STATE OF NORTH CAROLINA
DEPARTMENT OF TRANSPORTATION

May 8, 2013

Subject: **Response to On Hold Letter** for request for Section 401 Water Quality Certification Modification, Wilmington Bypass from north of US 74/76 in Brunswick County to US 421 in New Hanover County. DWQ Project No. 10-0867v.4. TIP R-2633B.

Reference: NCDOT Modification Request, dated April 3, 2013
NCDWQ On Hold Letter, dated April 19, 2013, received April 26, 2013

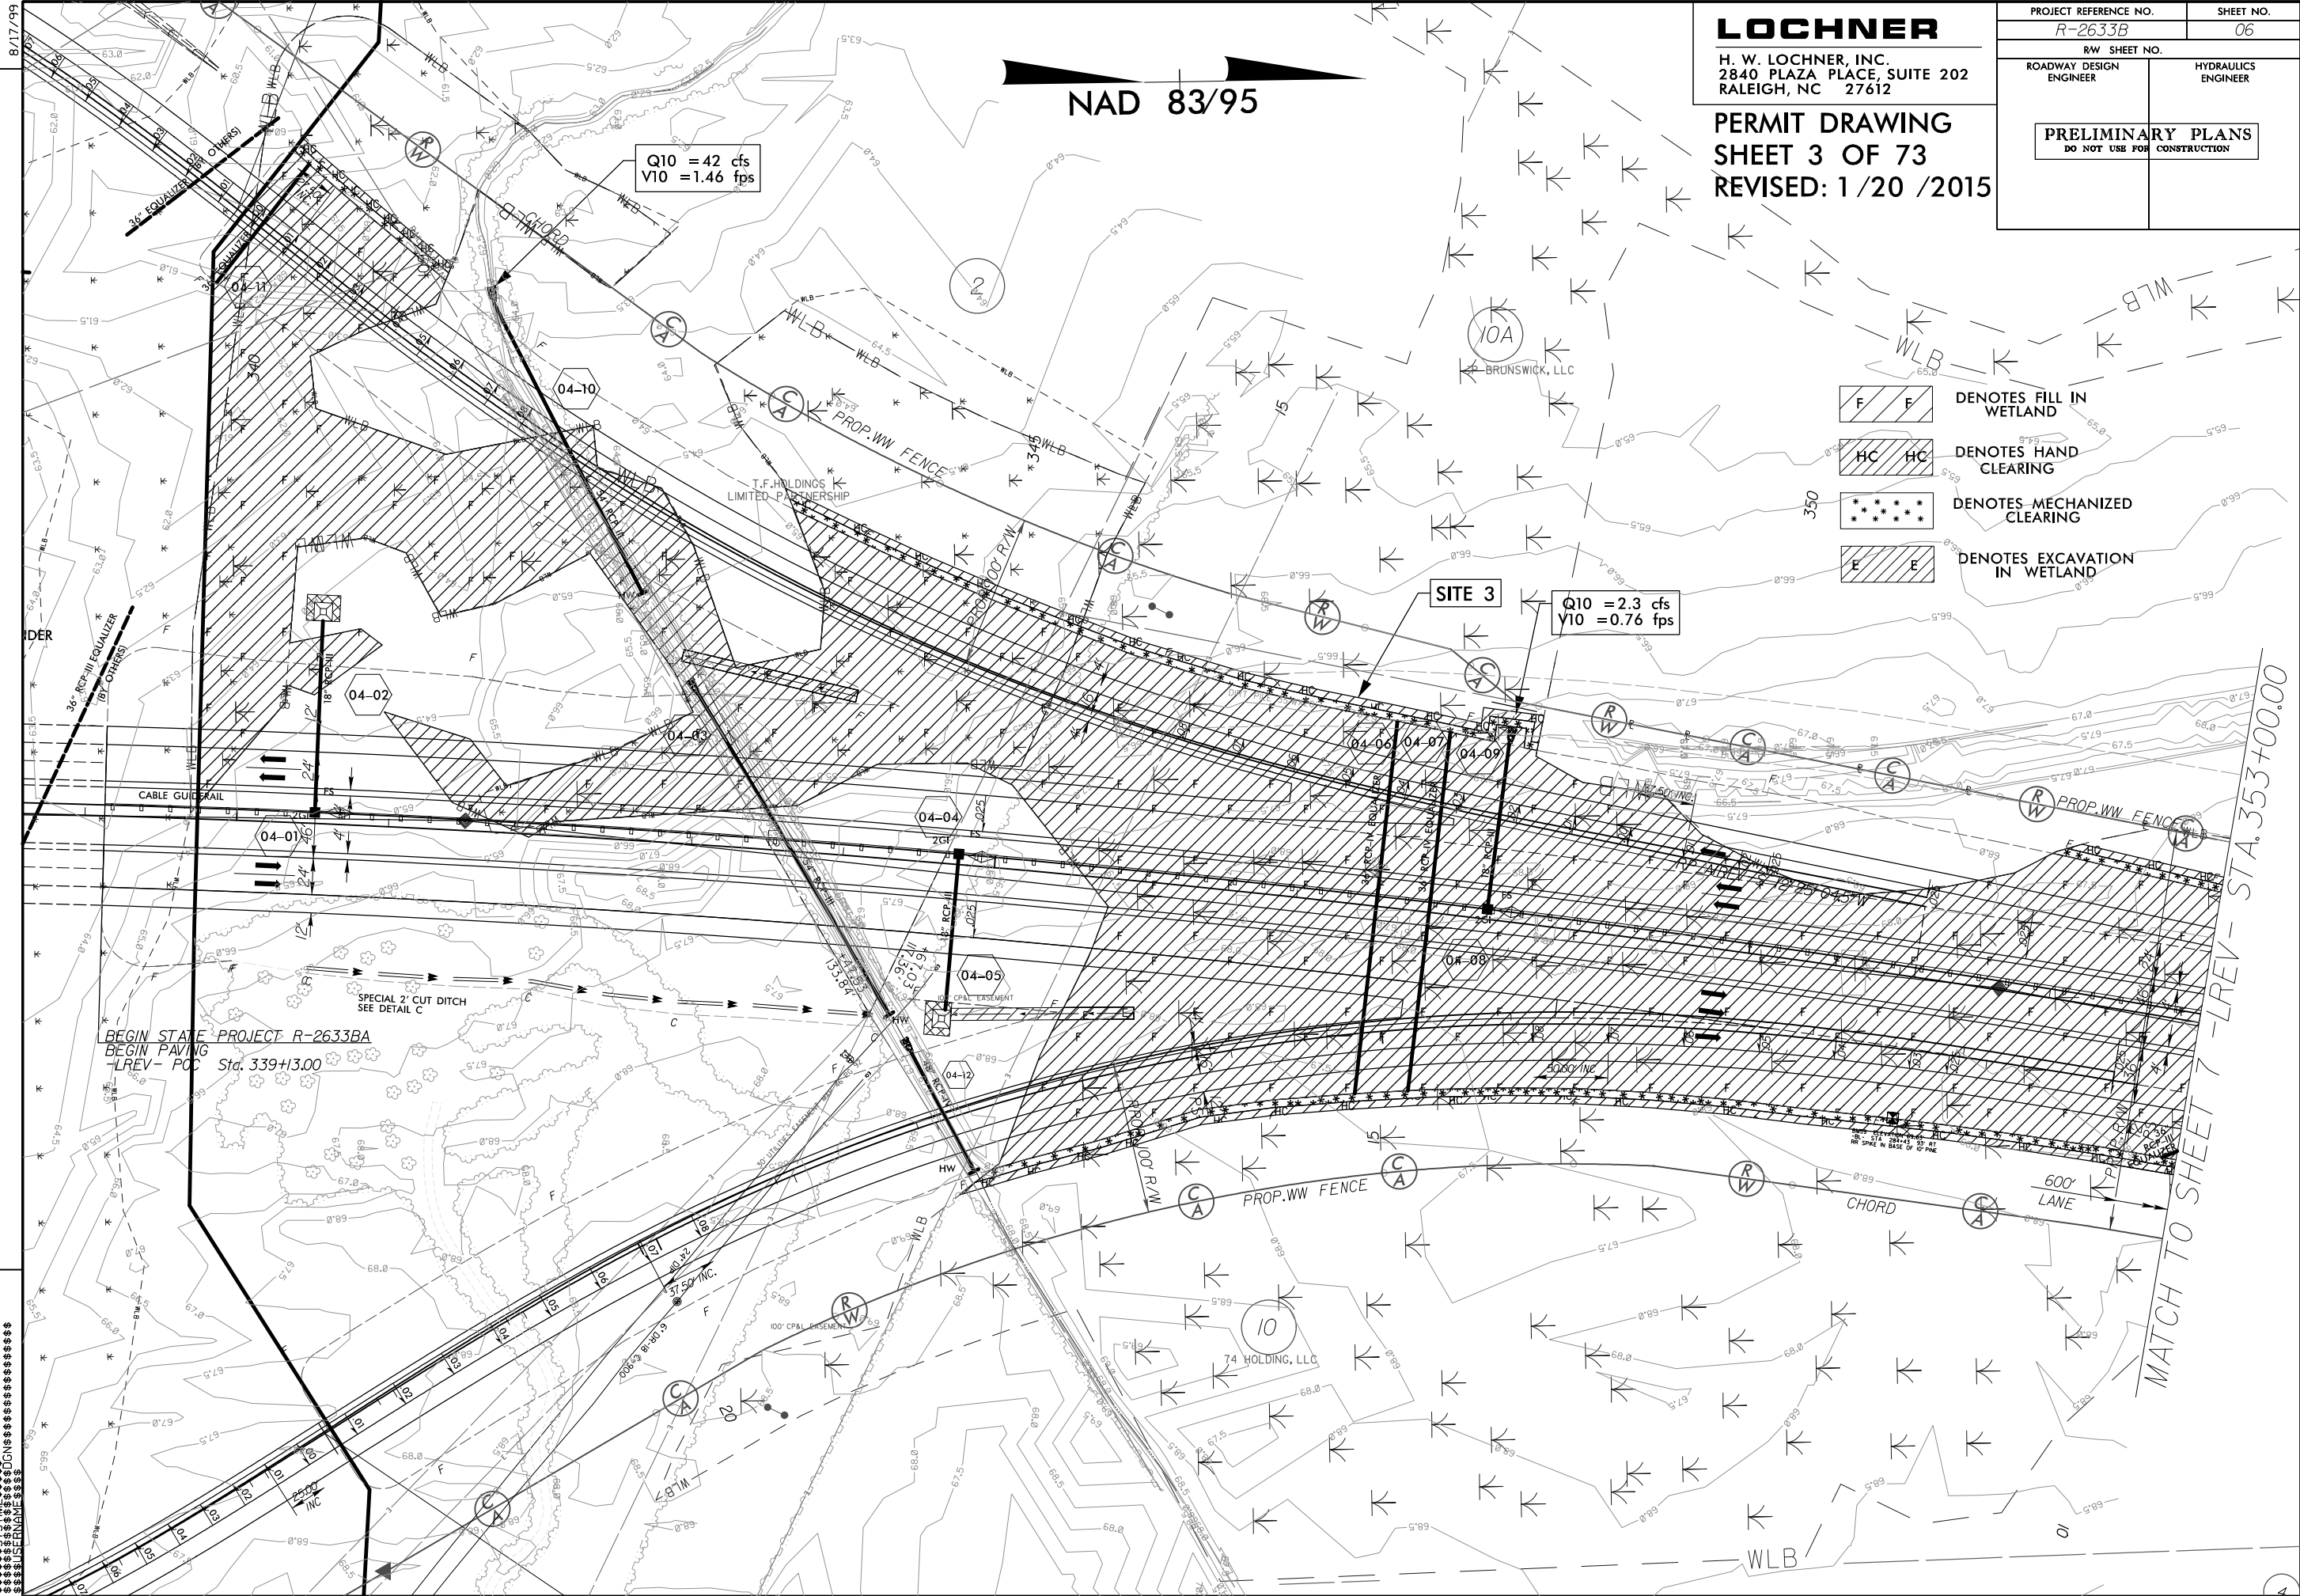
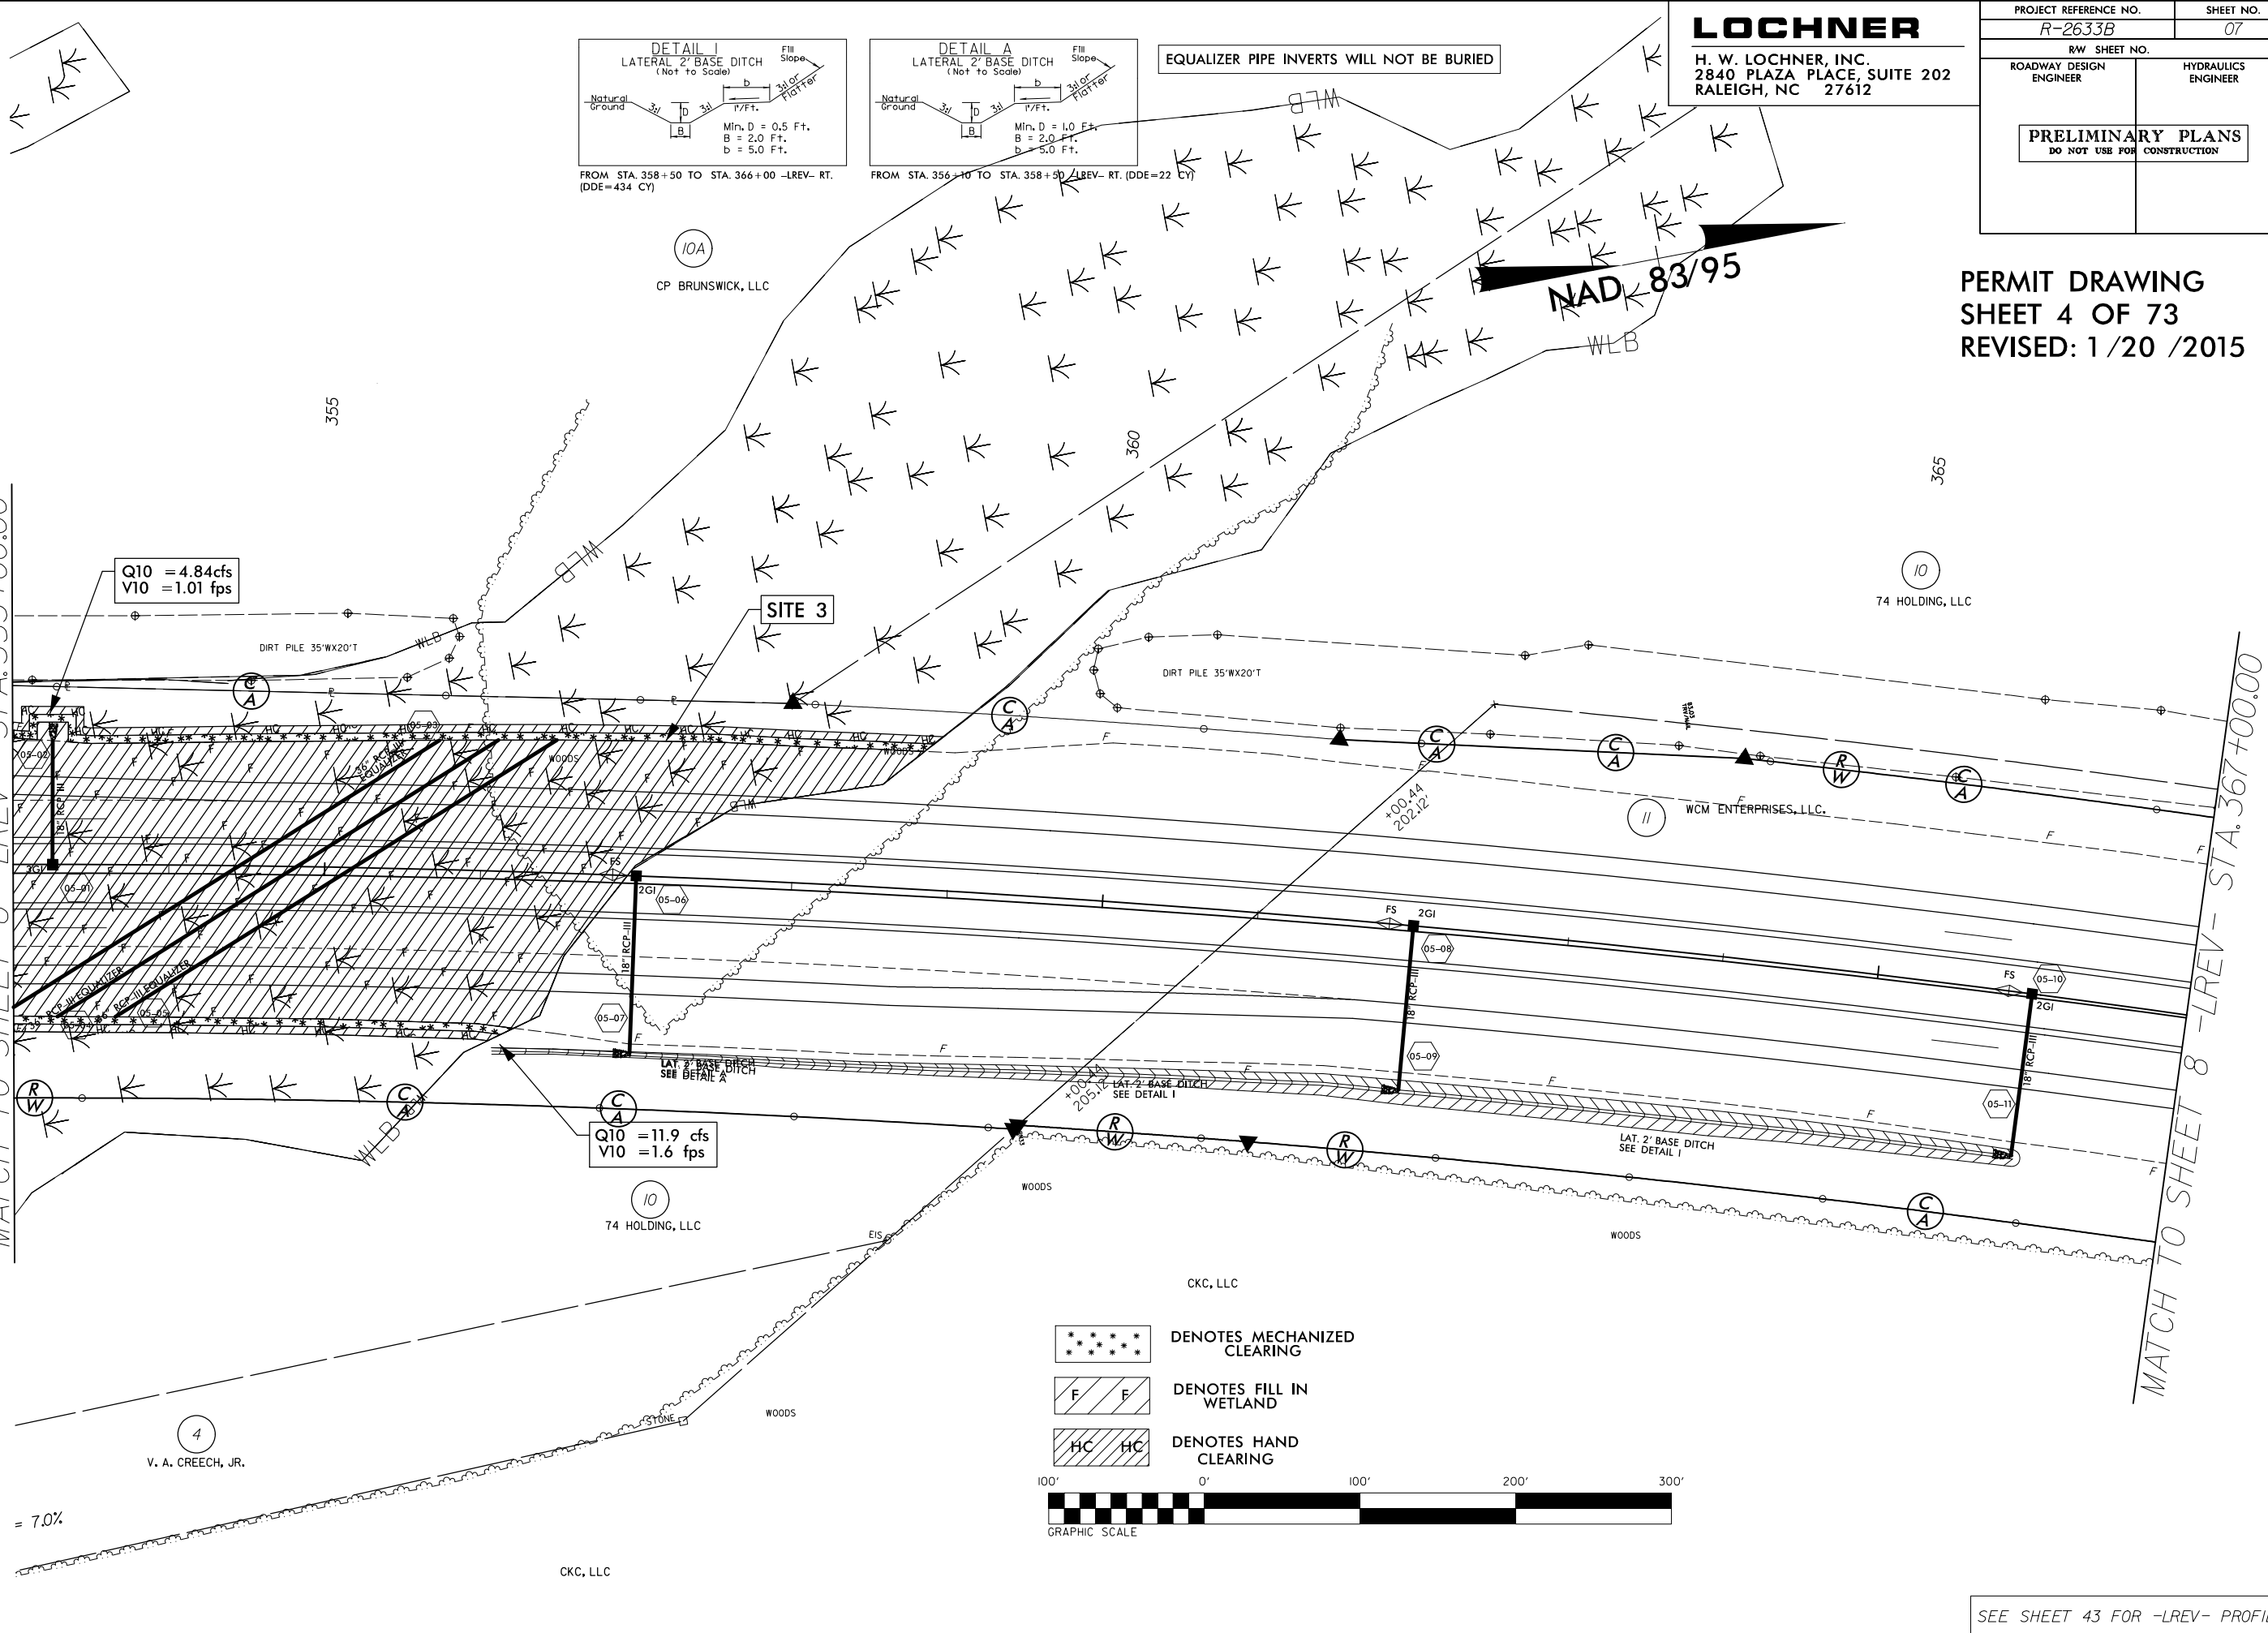
1. *Sites 3 & 5 – the cross section station numbers do not match the station numbers on the plan sheet. Also, the match line station numbers do not match the stations on the plan sheet. The station numbers in the impact summary and on the plan sheets run from 40+57 to 75+00 but the cross section numbers are listed as 345+00 to 375+00. Please change the cross section station and match line stations to coincide with the stations along the –L– line on the plan sheets.*

1. Sites 3 & 5 – the cross section station numbers do not match the station numbers on the plan sheet. Also, the match line station numbers do not coincide with the stations on the plan sheet. The station numbers in the impact summary and plan sheets run from Sta. 40+57 to 75+00 but the cross section numbers are listed as Sta. 345+00 to 375+00. Please change the cross section stations and match line stations to coincide with the stations along the -L- line on the plan sheets.

The station numbers on the impact summary sheet have been revised for sites 3 & 5. A slight change in the design for R-2633A resulted in the need for a geometric alignment shift for R-2633 BA (LREV) to tie the two sections together. Both sets of stations are correctly shown on the Permit Drawing Sheets 2, 3, 9 & 10 and an equality point is provided on Permit Drawing Sheets 9 & 10.
